Your Ref: OWPC20201
Our Ref: AW/248/18/HH 21-08-2018
Please ask for:
Richard Castro-Parker

Front two storey extension
13 Gossamer Lane Aldwick

Thank you for your internet representation made on 14th October 2018 which has been recorded as '**an objection**' with the comments as follows:

DRAWING BLOCK PLAN	SCALE 1/500
DATE: JULY 2018	
DRAWN: T. Murray	
DRAWING: 18/38/3	REVISION:

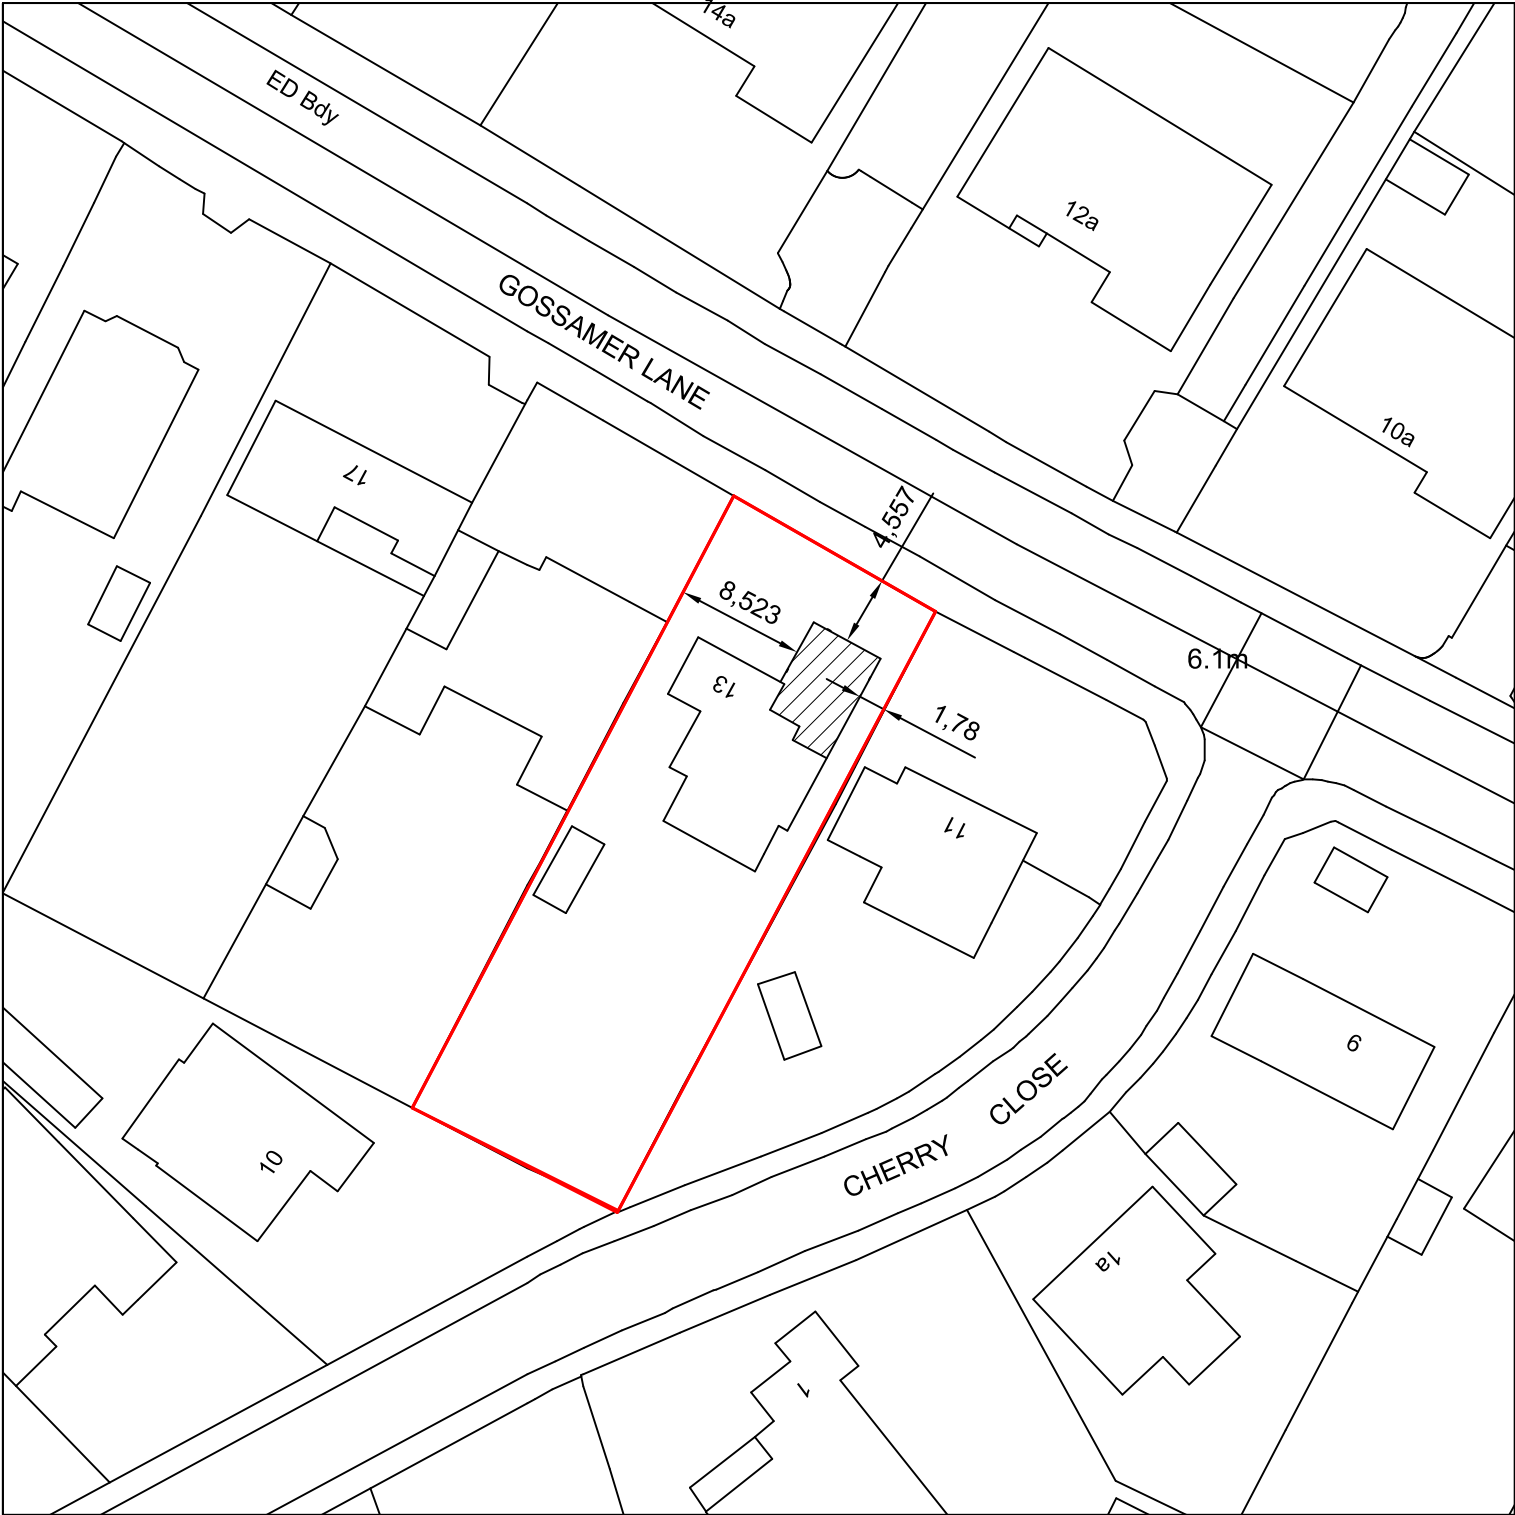
- 1. The proposed extension will far exceed the building line of existing properties 1 in the road and will effectively be in front of my house, therefore being visually dominant.*
